Department of Transportation

January 24, 2020

RE: Pearson's Ministries - dba Legacy Church - Hydraulics and Site Development
Plan_PPR1933

REV: 11/22/19
REV: 10/18/19
PROPOSED DRAINAGE PLAN
SHEET 2 OF 3

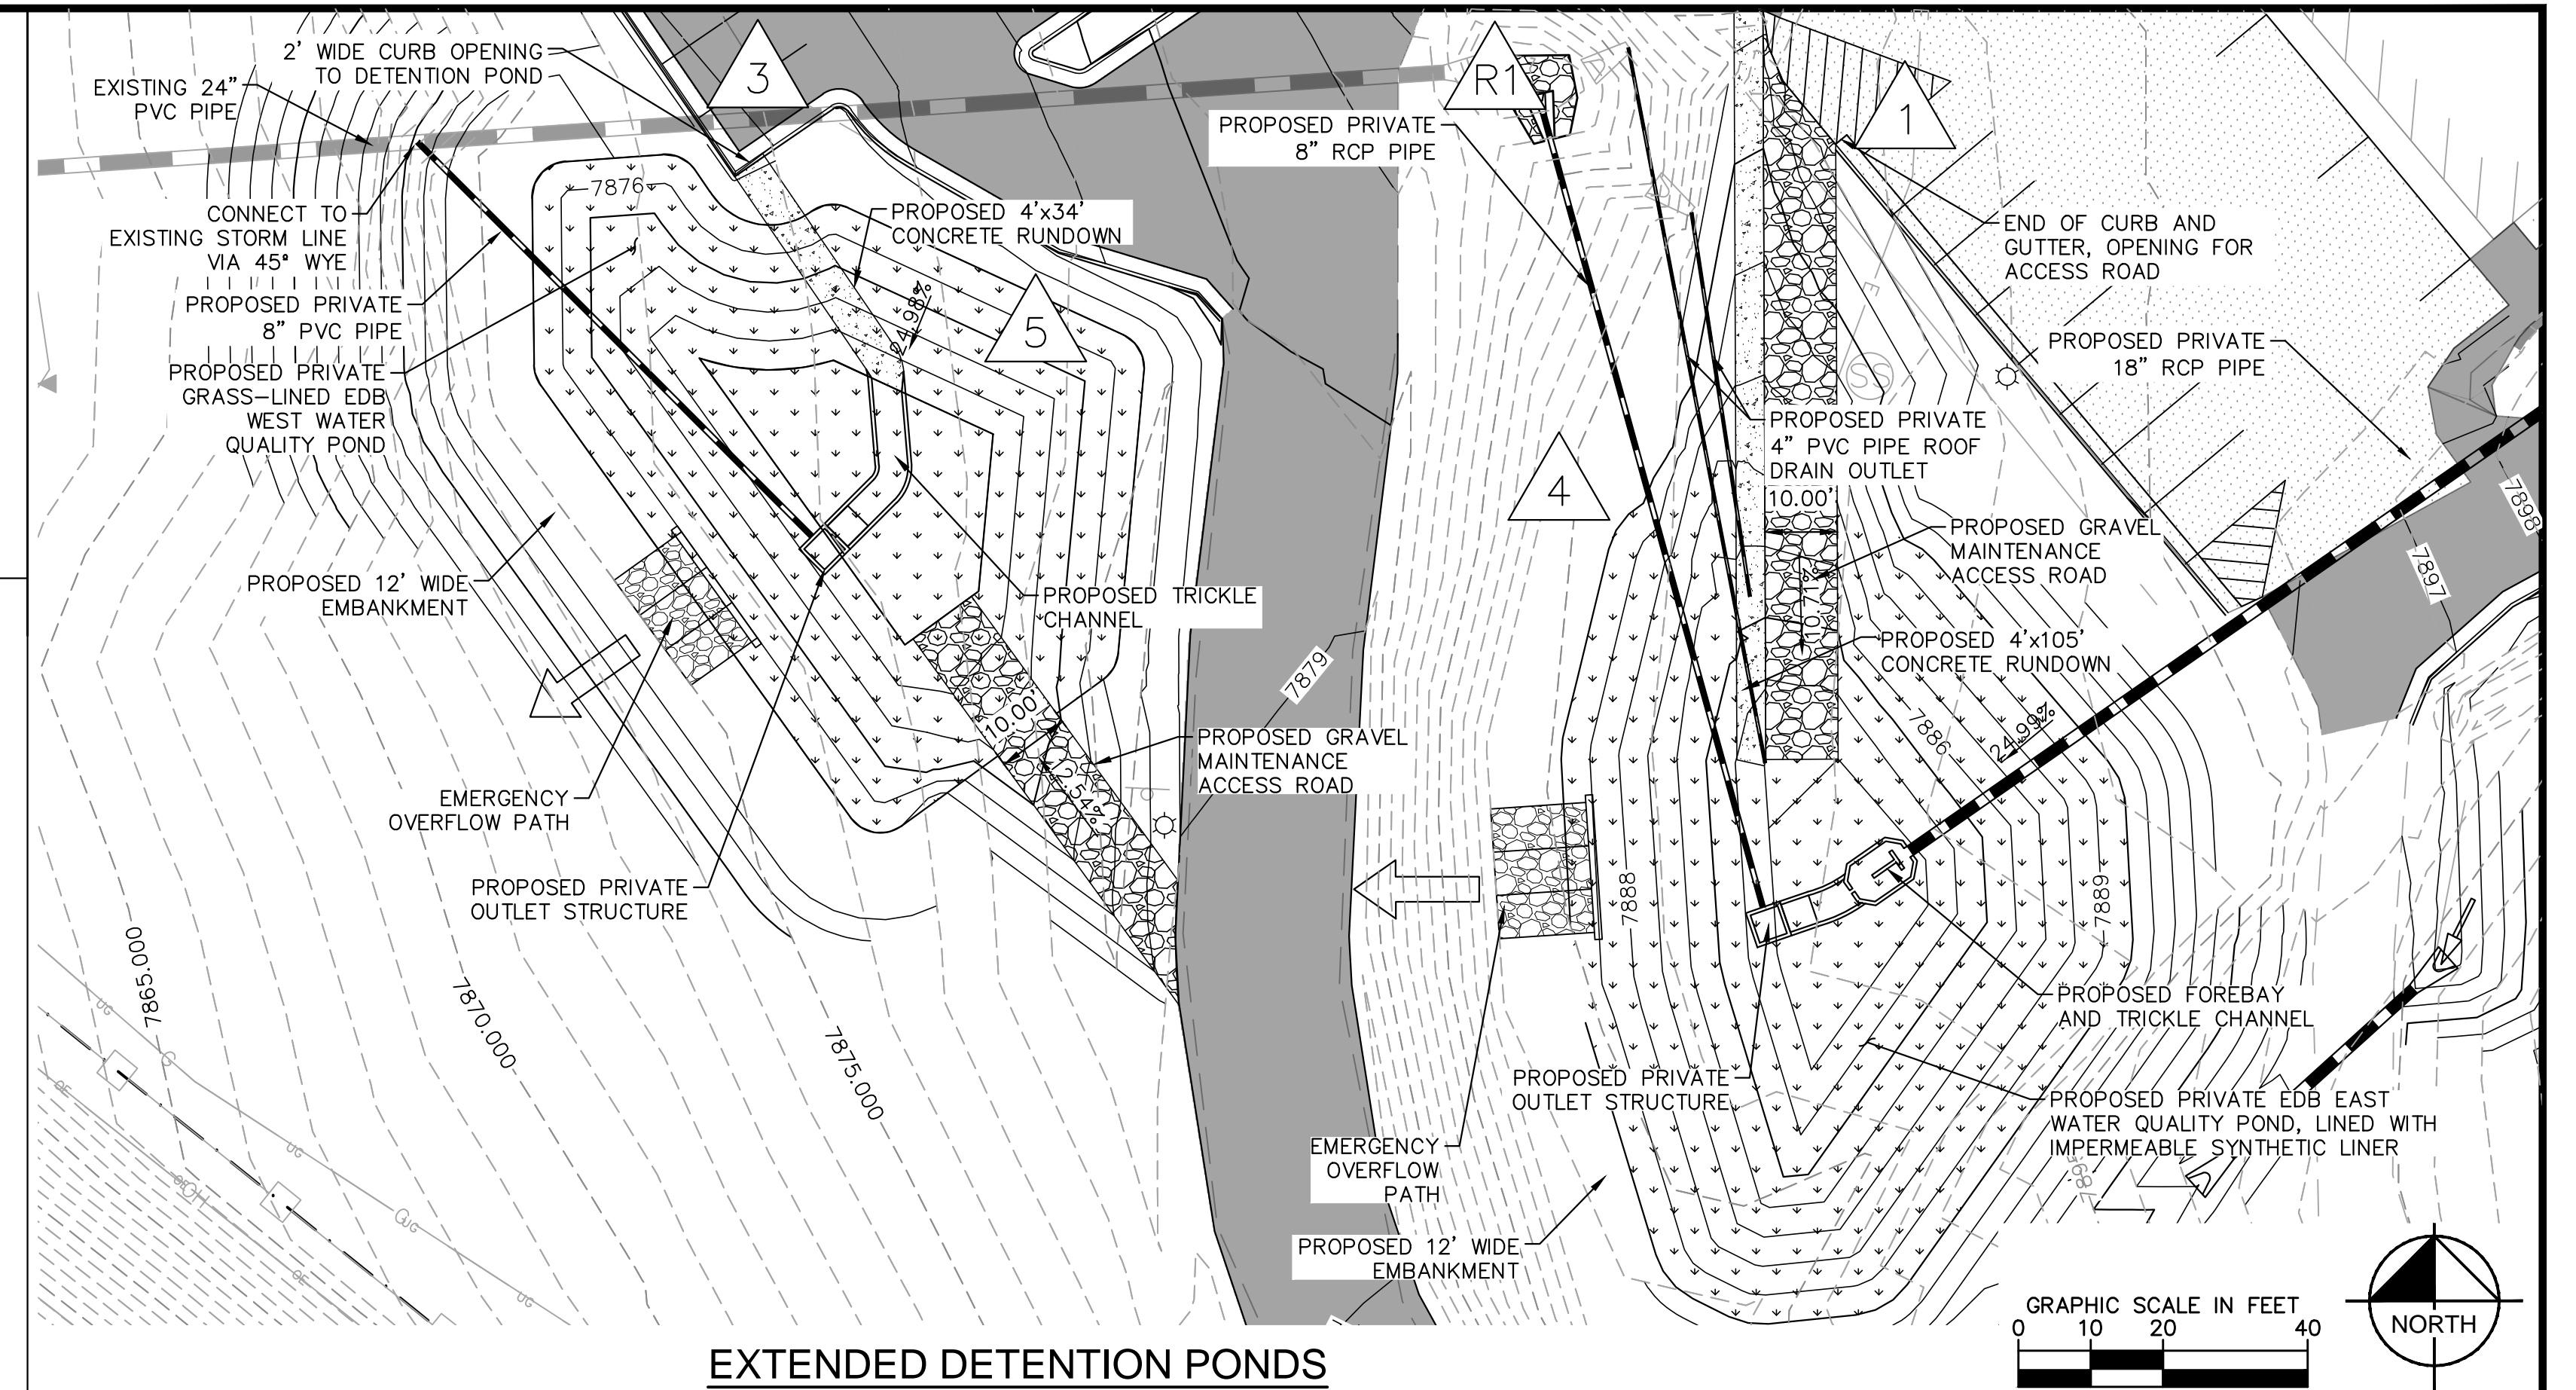
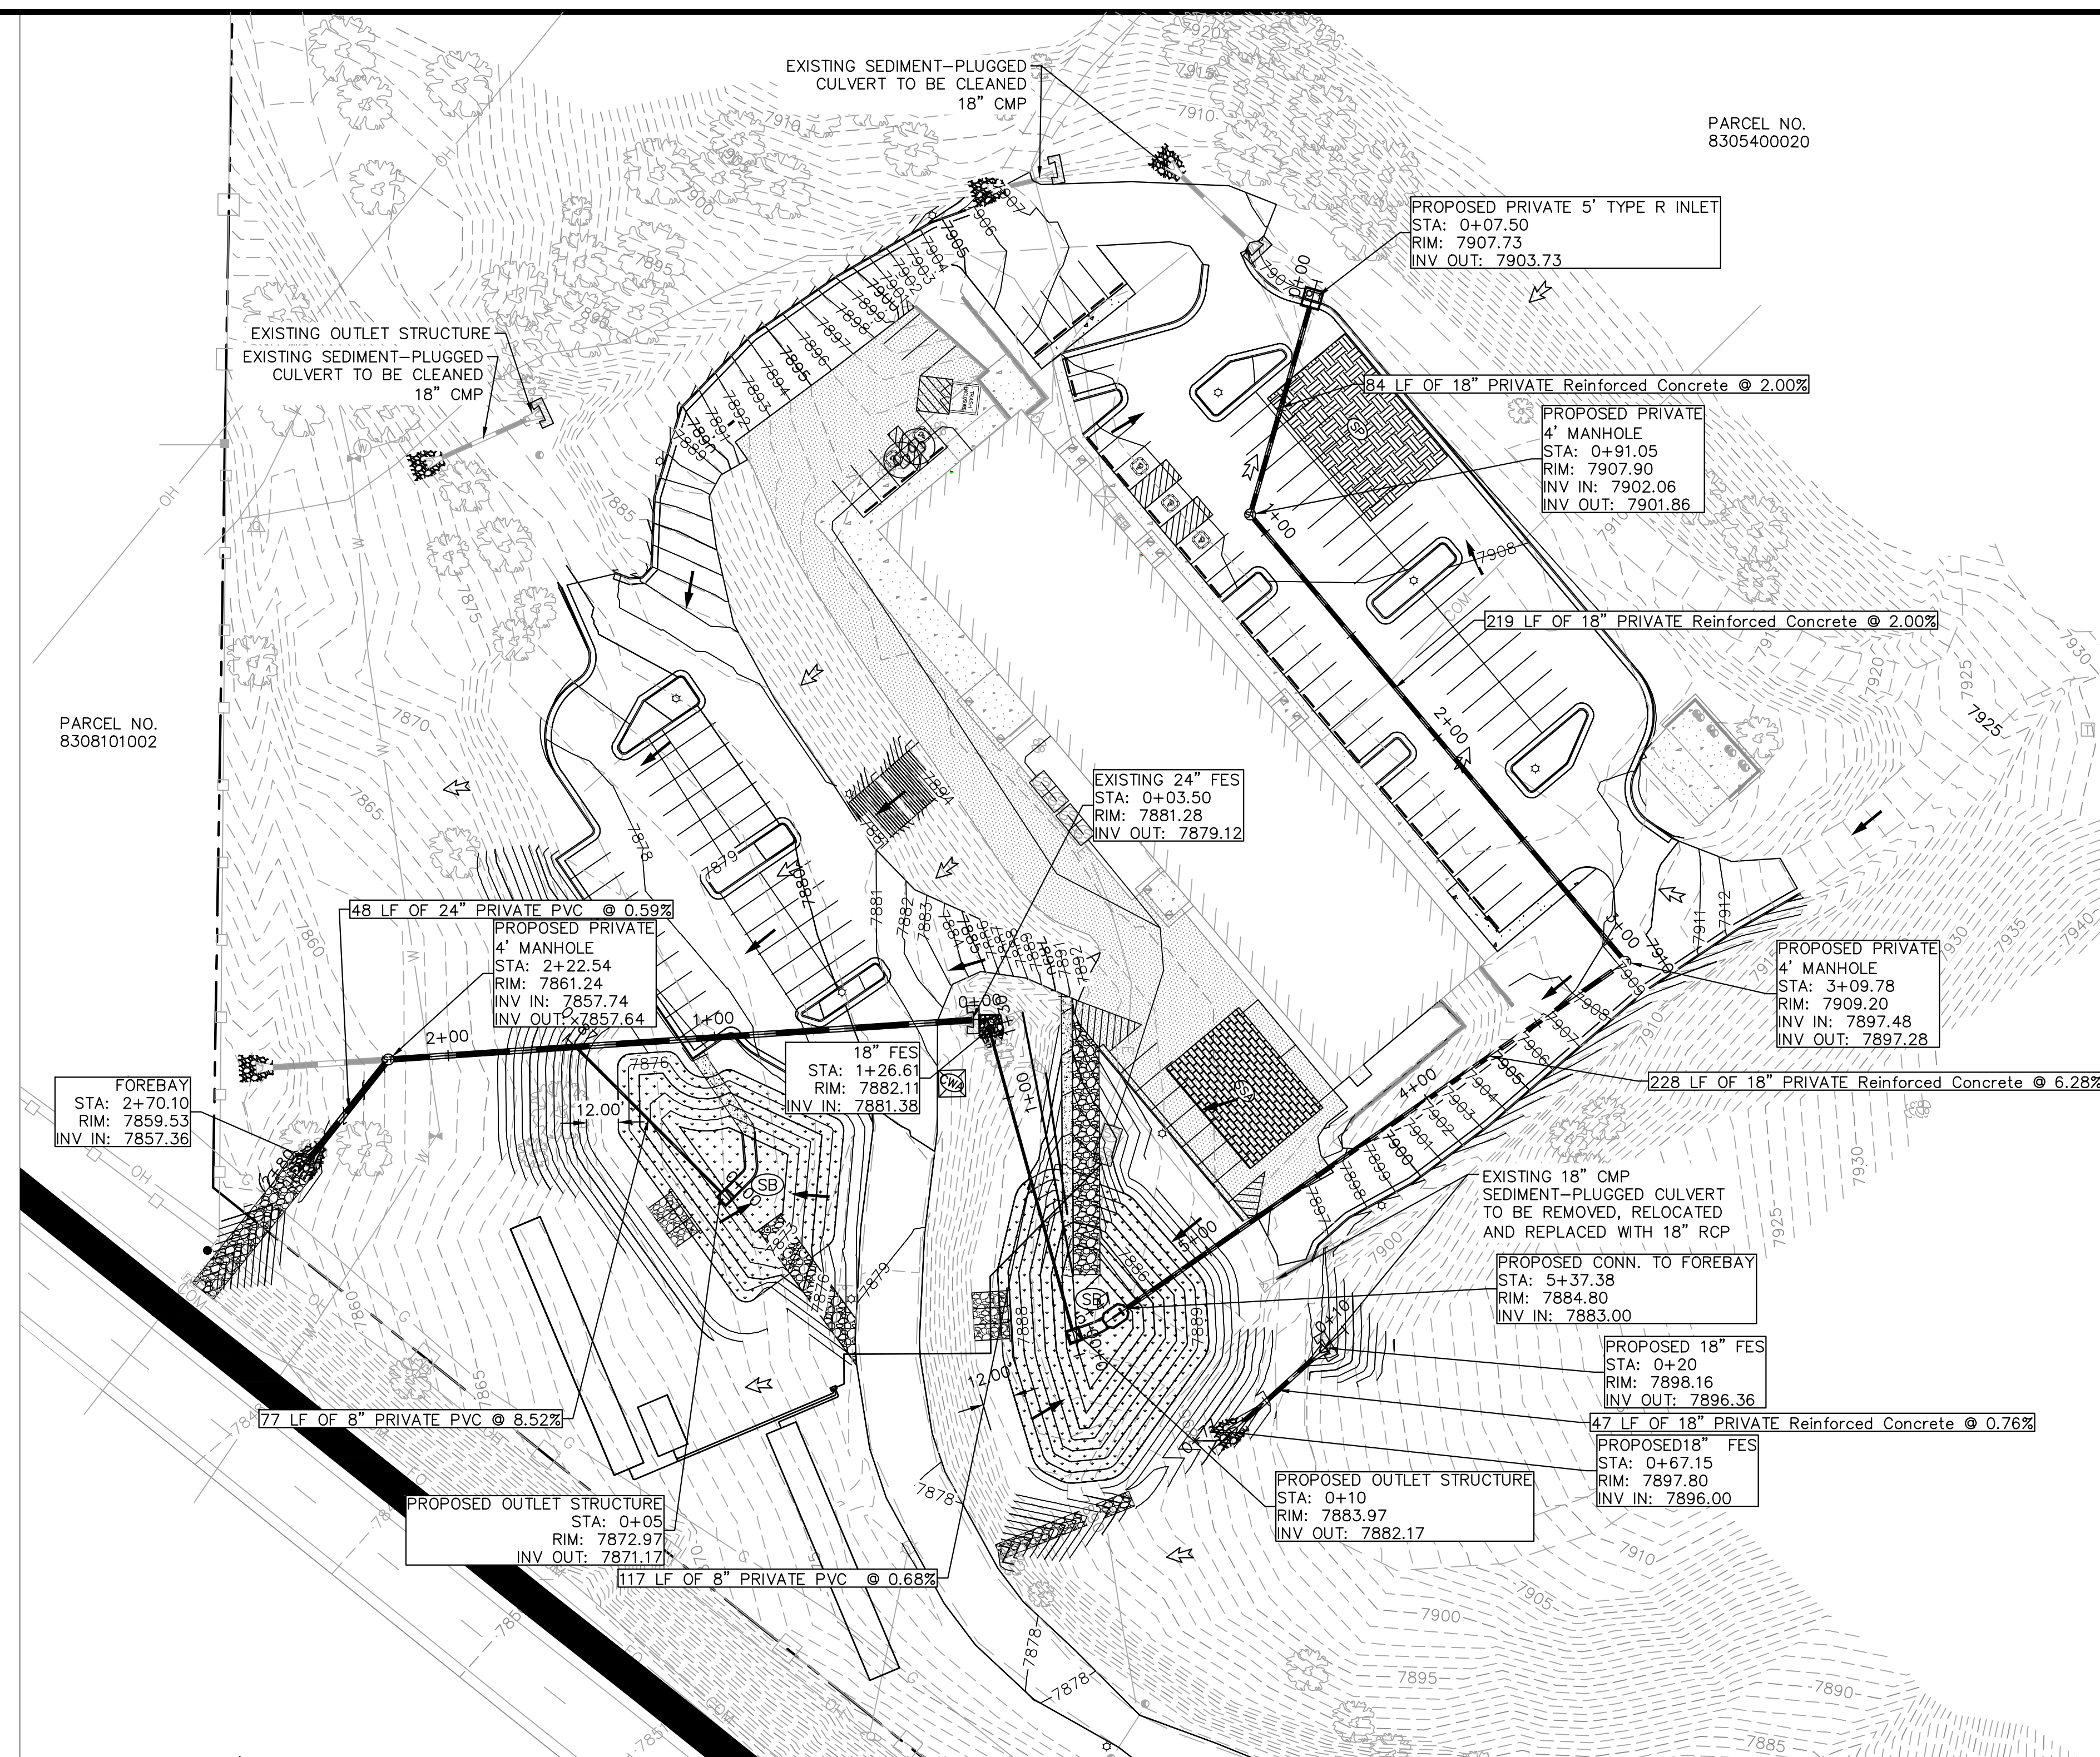
- c. Existing 24" pipe draining to the southwest is shown connecting to a pipe that appears to be proposed by this project, sheet 4. Details are missing, please provide.

- d. Riprap rundown shown at the outlet of the proposed pipe run C01. Need to see construction details and calculations that show the proposed riprap design is adequate. Drainage report mentions that this is a concrete rundown. Which is it? Need to ensure that it extends to the bottom of the CDOT ditch and up the ditch back slope to ensure the ditch is not eroded.

- l. A culvert and ditch were added southeast of the east detention basin. This ditch outfall onto the church access road. This concentrated flow outfall condition will cause erosion along the edge of the proposed drive and likely undermine the pavement as well as cause icing issues in winter. Please provide a way for this water to drain either in a ditch along the access road or another culvert under the access road to prevent erosion.
